CITY COPY
16350 MIDWAY RD

PROPOSED FACILITY FOR:
BAS REALTY
LIMITED PARTNERSHIP

SITE PLAN

A1.0

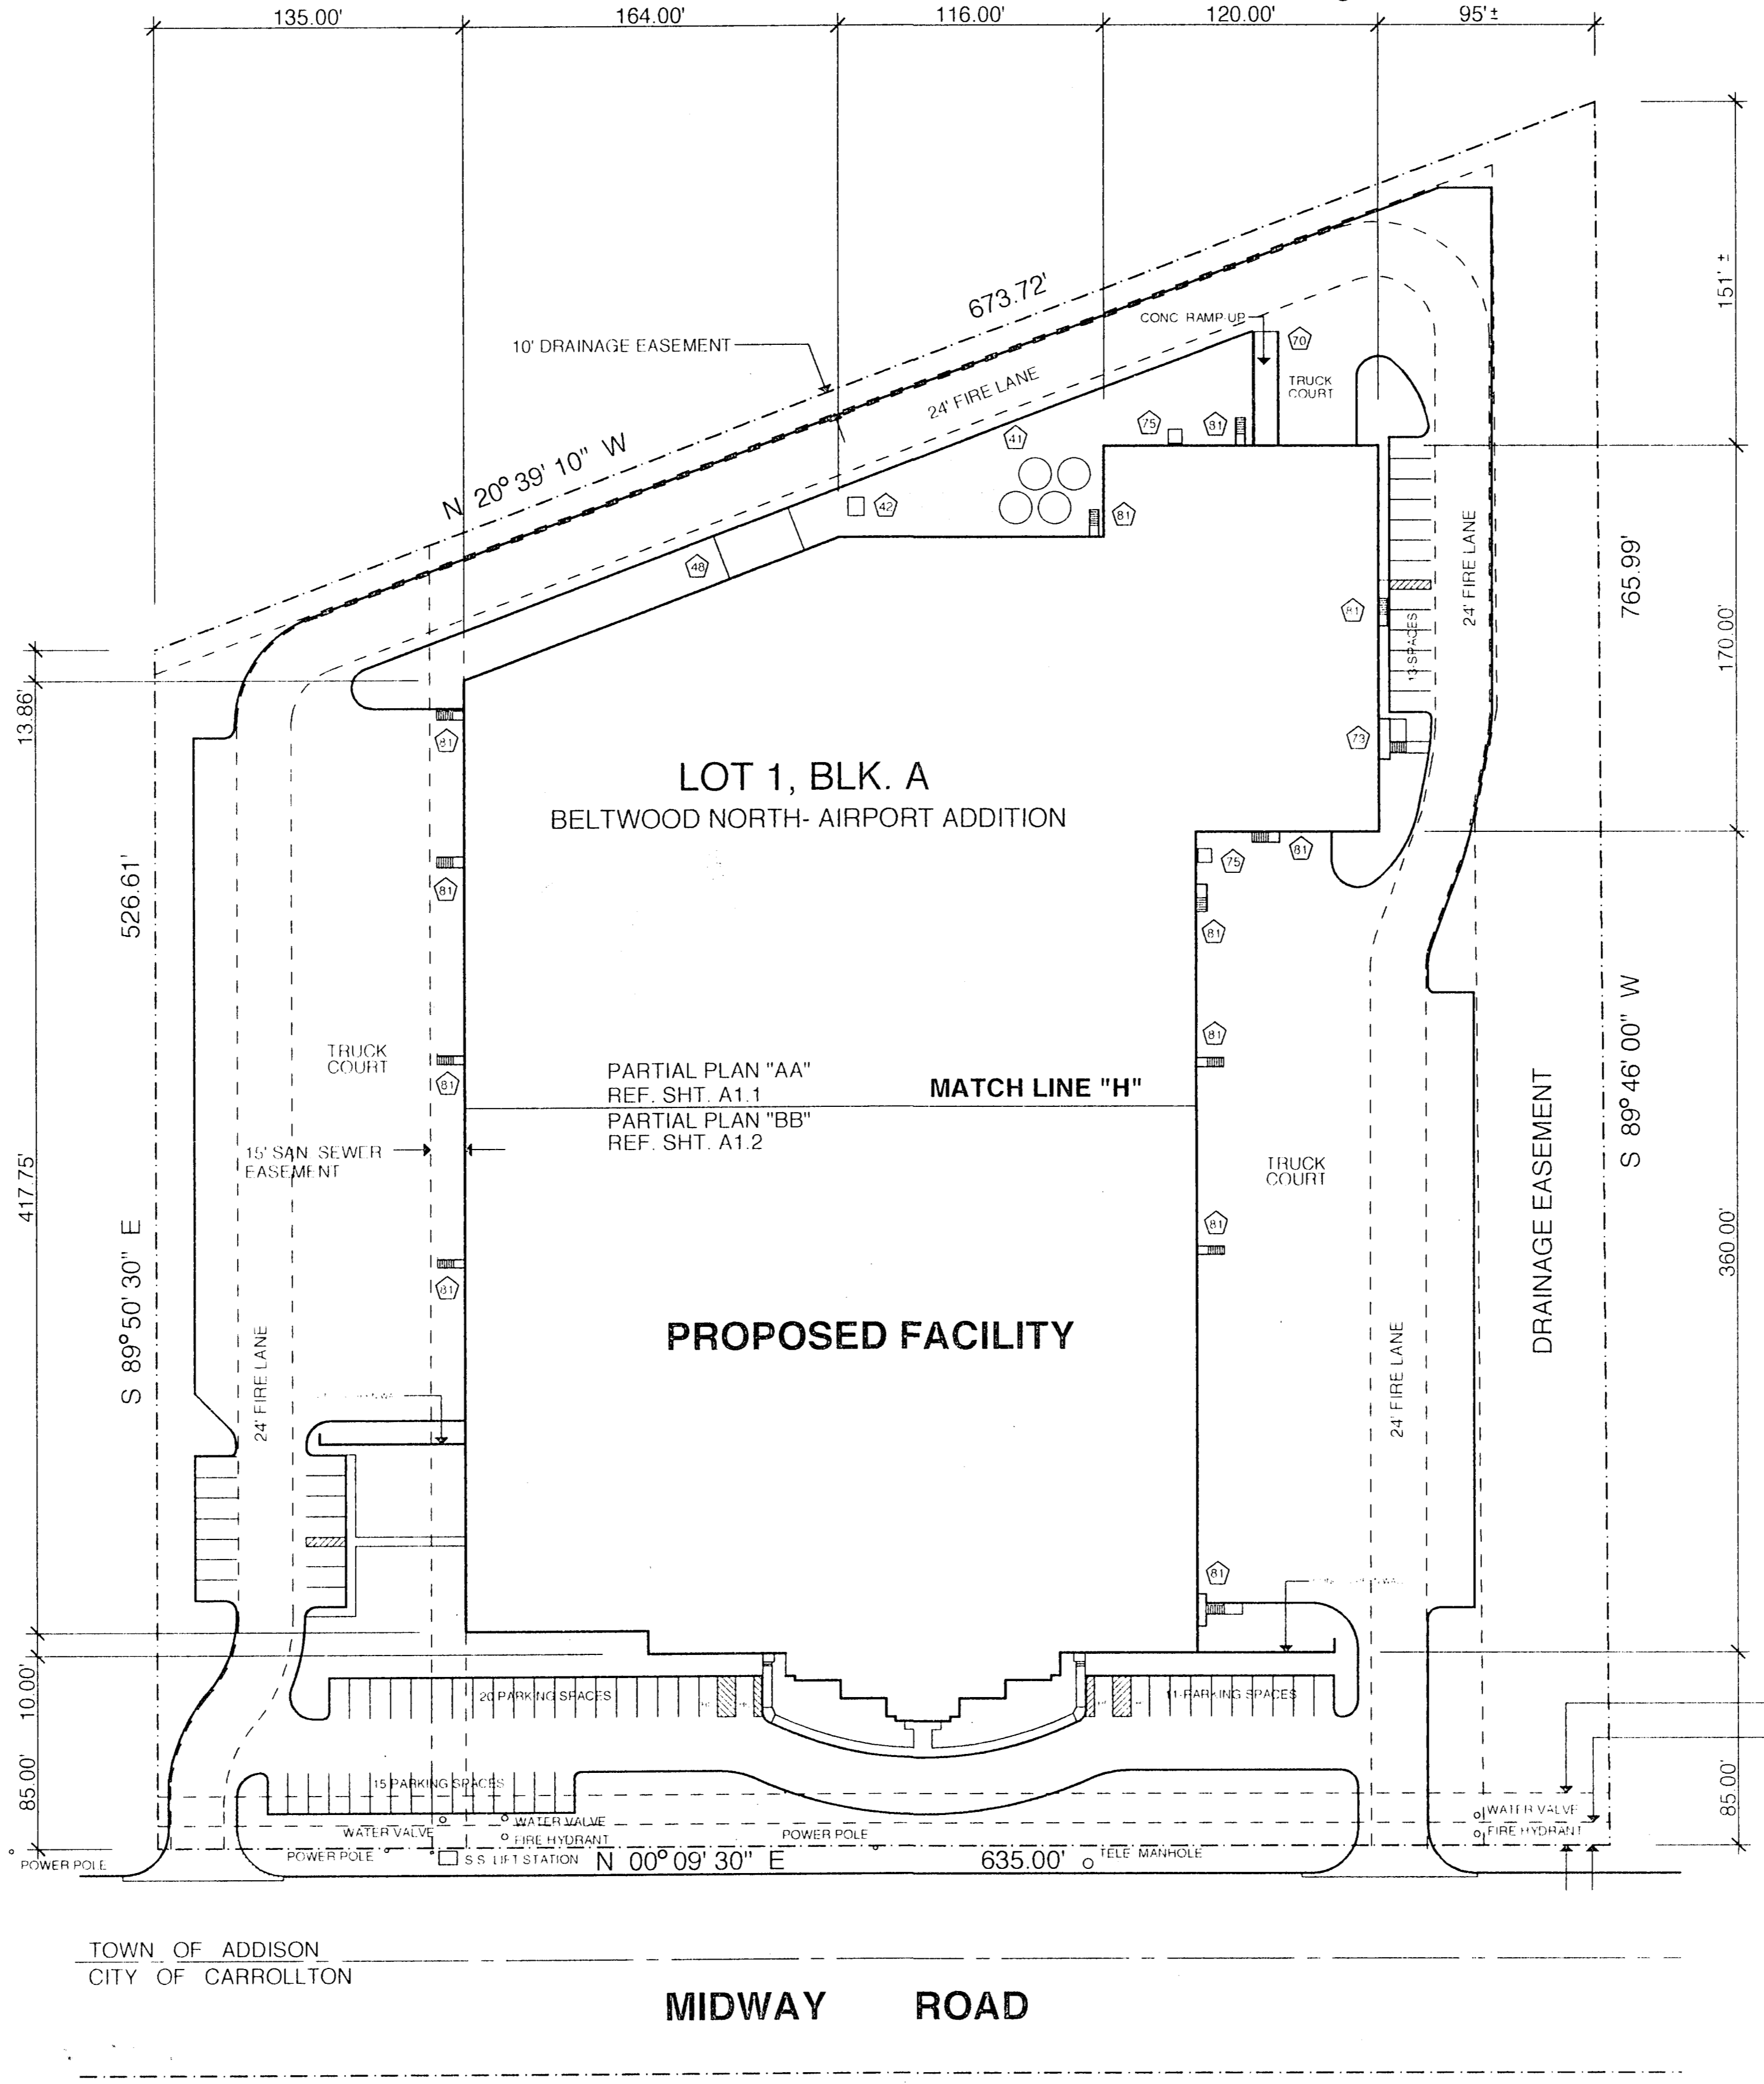
*Domestic under to have double check
Add vent to S. Trap see p. 20.*

1. UPON COMPLETION OF PROJECT ARCHITECT MUST SUBMIT A LETTER STATING THAT BLDG AND SITE MEET THE ACCESSIBILITY REQ. OF CH 31 OF THE 1991 LBC

DATE	4-20-95
JOB NO.	95010
REV. DATE	5-10-95
REV. DATE	
REV. DATE	
SHEET:	C1.1

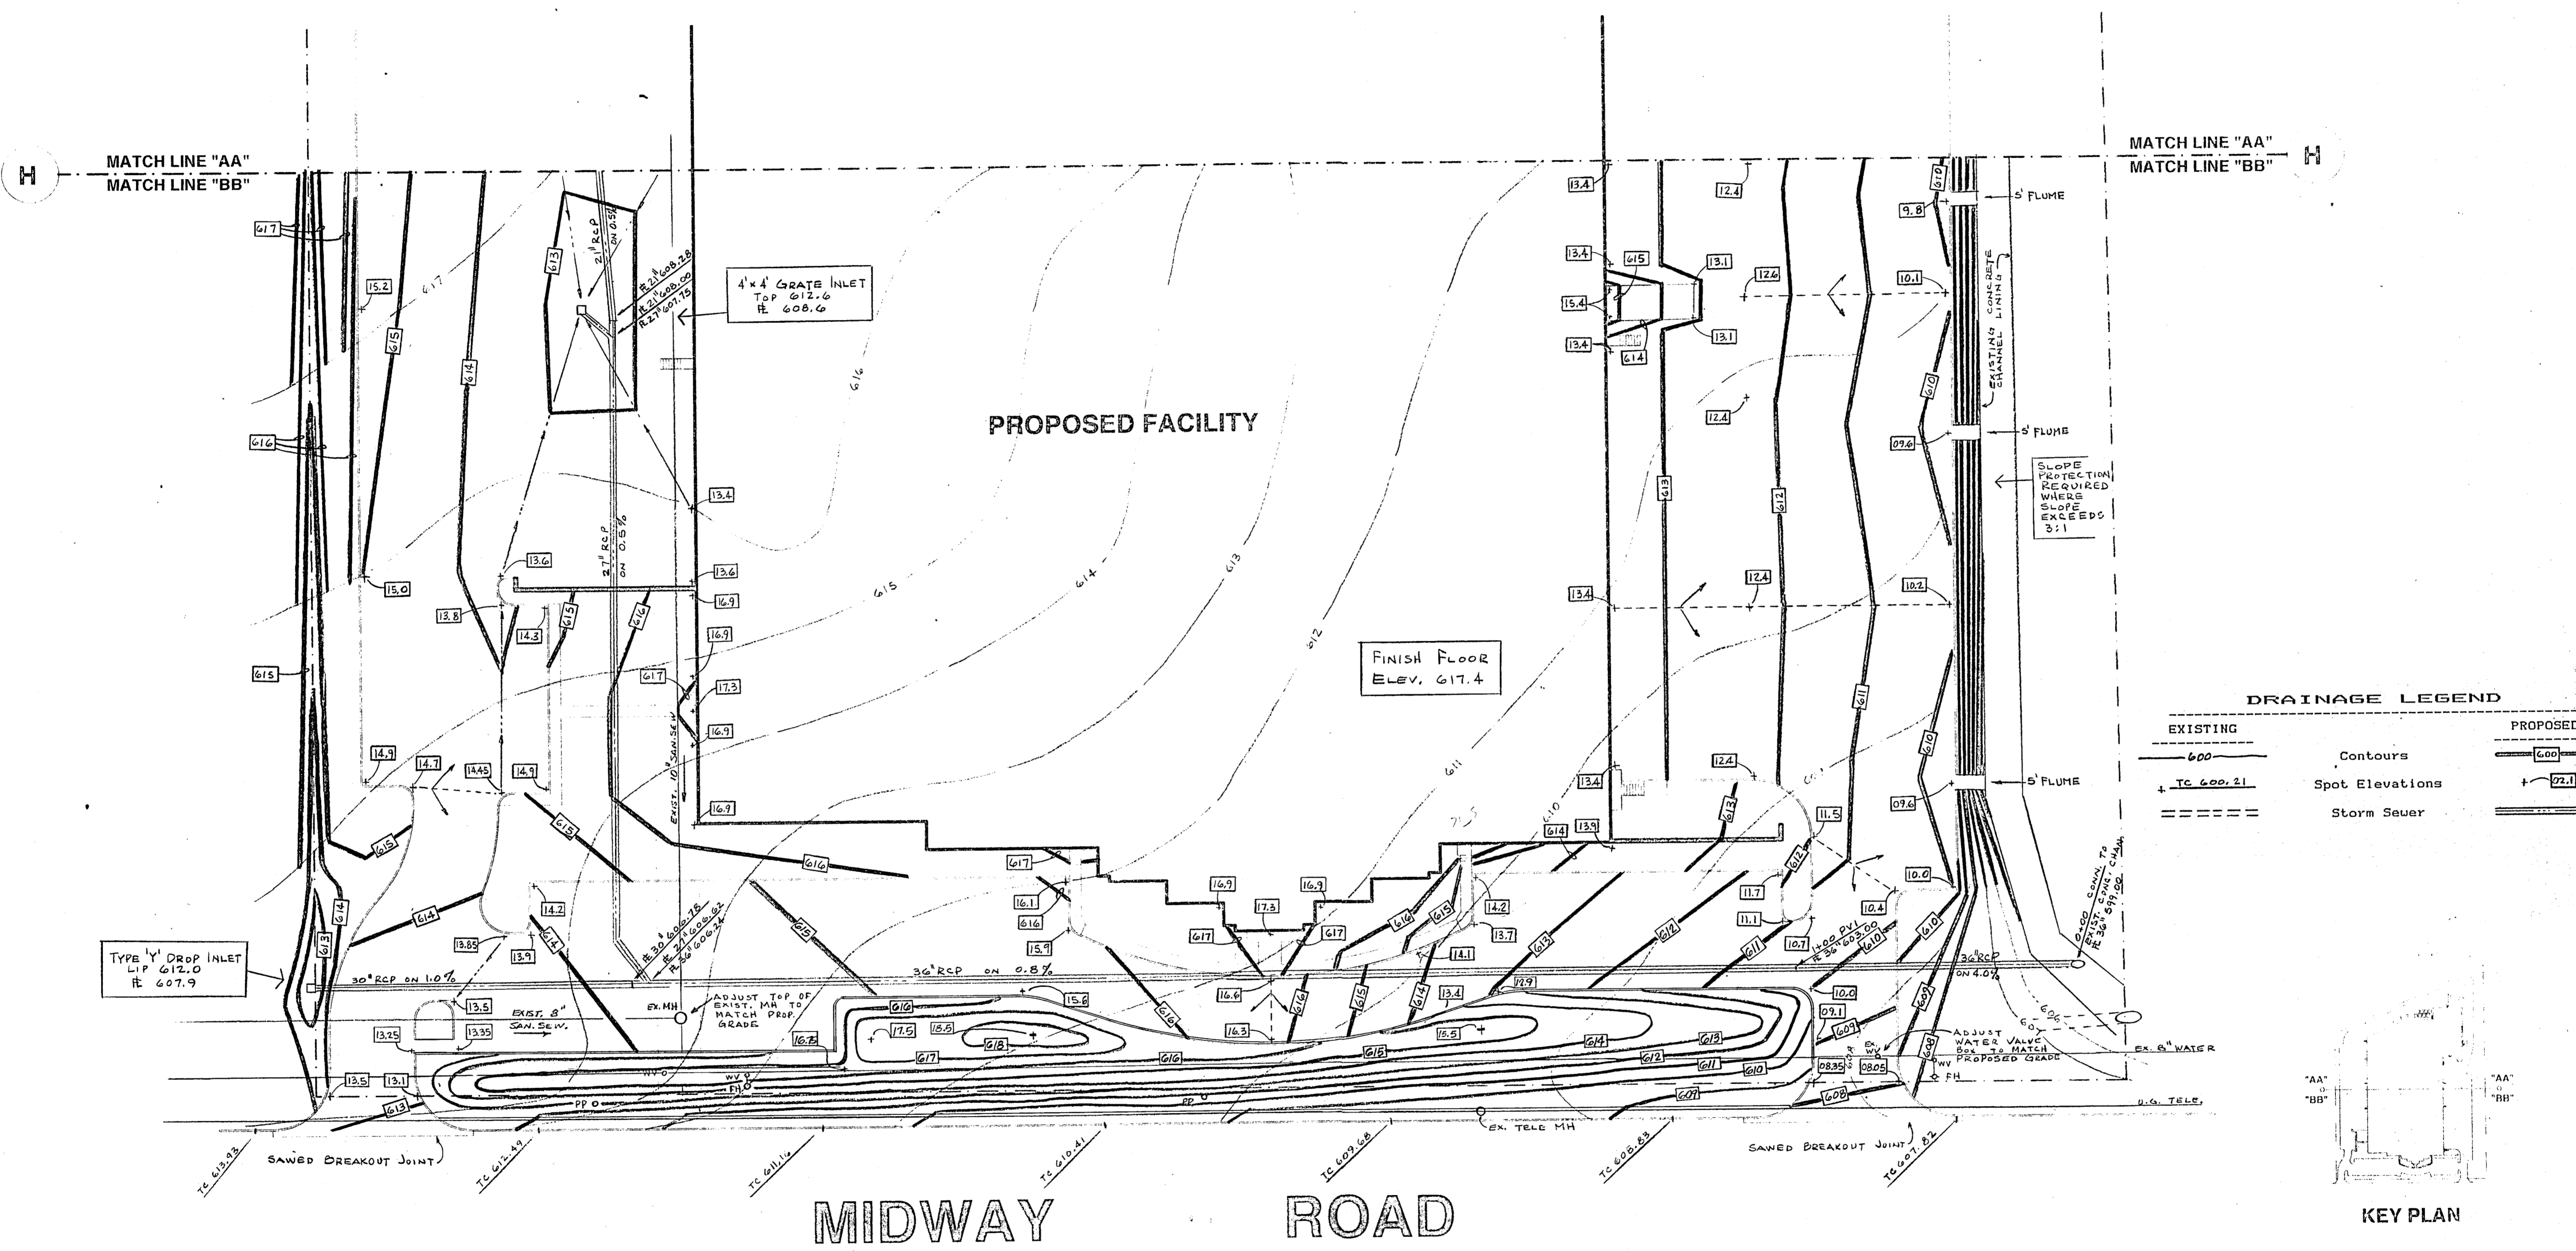
All areas disturbed by construction shall be revegetated
 JRB
